REPORT UPDATE

Application No: LU/67/18/PL

REF NO: LU/67/18/PL

LOCATION:	14-18 Surrey Street Littlehampton BN17 5BG
PROPOSAL:	Change of use of part of public highway for external seating area at front comprising of 3 No. tables & 6 No. chairs. This application may affect the setting of a listed building.

CLIENT	JD WETHERSPOON PLC		
PROJECT	PUB NO: 534 THE GEORGE INN LITTLEHAMPTON		
DRAWING	PROPOSED PAVEMENT CAFE		
SCALE	A3/1:50	DATE	MAR 2018
PROJECT No	7508	DRAWING No	03
		DRAWN	ALS
		REVISION

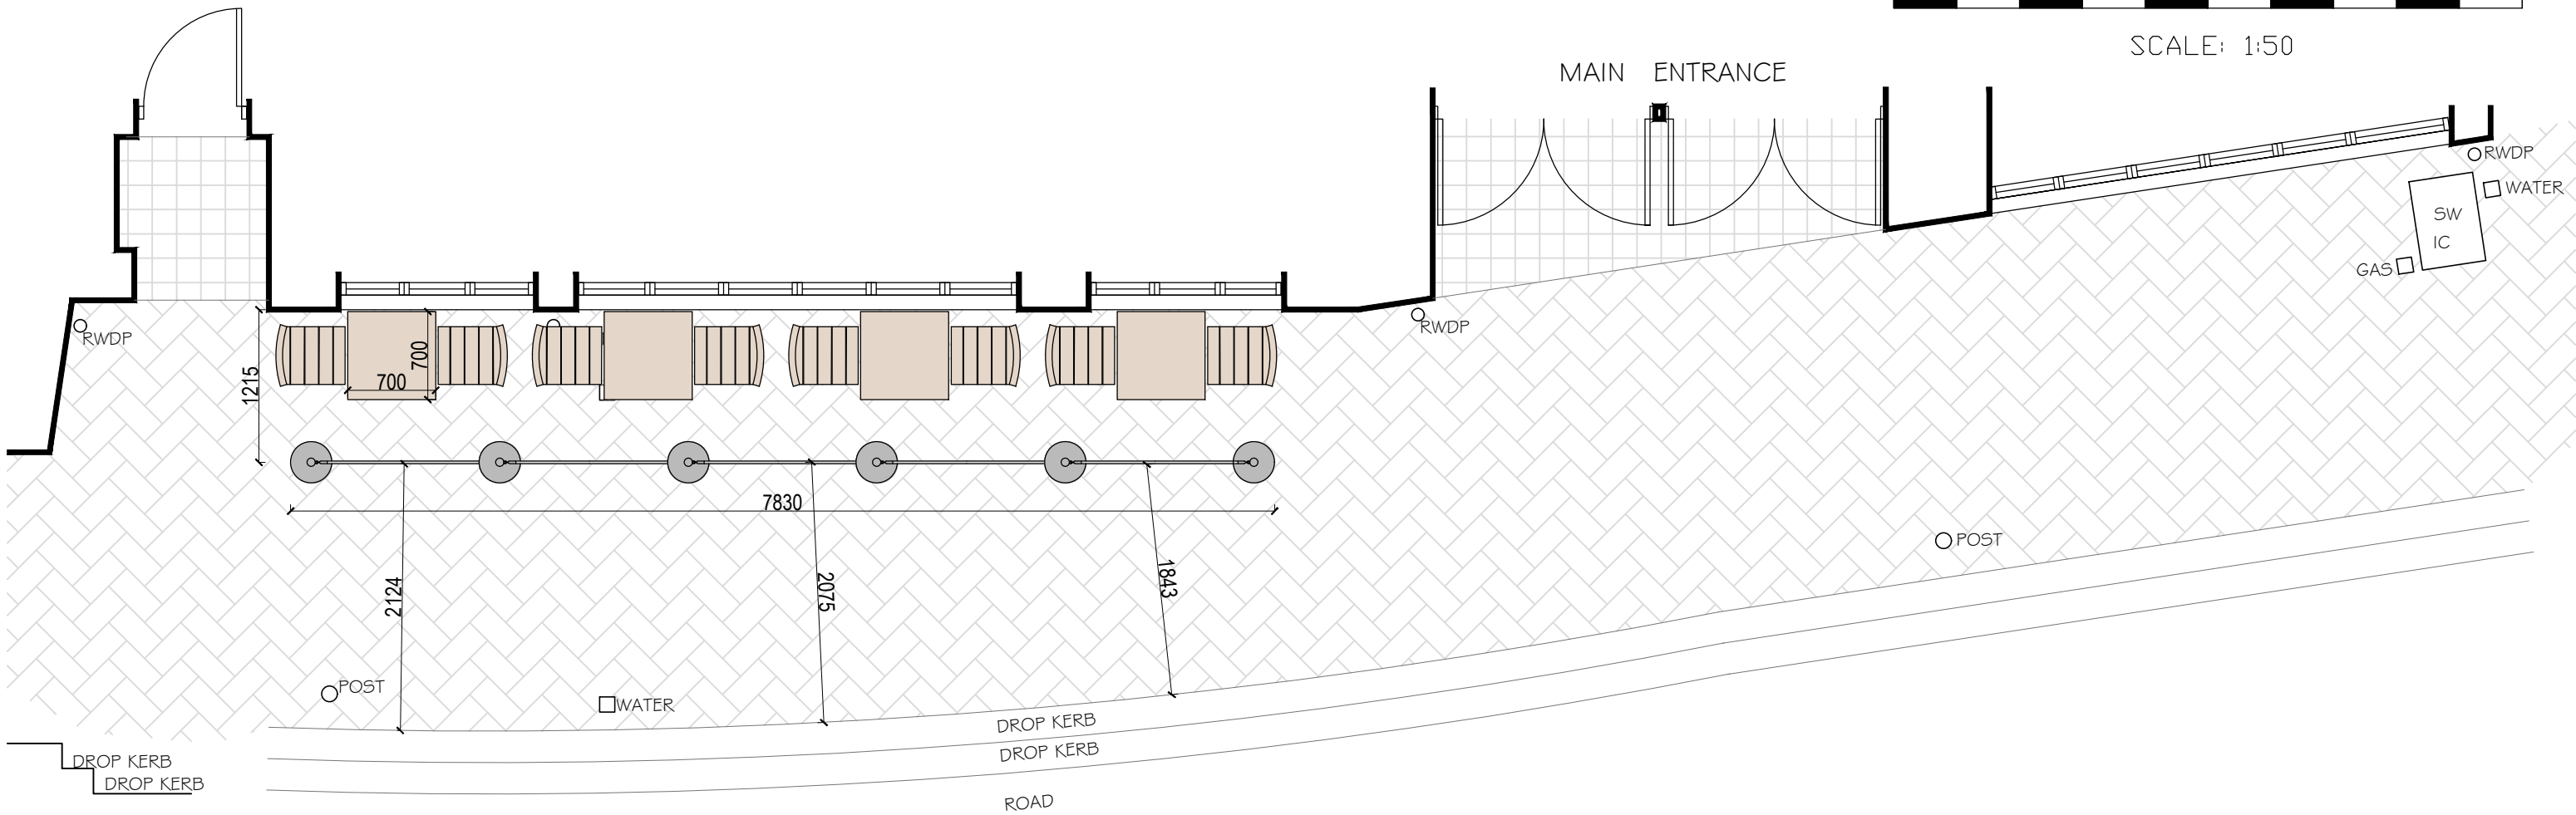
- The Highways Authority had yet to comment on the application.
- The plans presented with the application did not show the lamppost and highways sign at the front of the premises and the businesses along this stretch of Surrey Street which were also providing chairs and tables outside their premises.

The application originally submitted comprised 4 tables and 8 chairs and reduced the pavement width to between 2.1m and 1.8m. Following advice from County Highways the proposal was amended to reduce

number of seats to 6 and the number of tables to 2. The pavement width retained is now 2.2m to 2m.

This accords with highways advice and the proposal will therefore not unacceptably impede access along the footpath in conflict with policy GEN7 of the Arun District Local Plan.
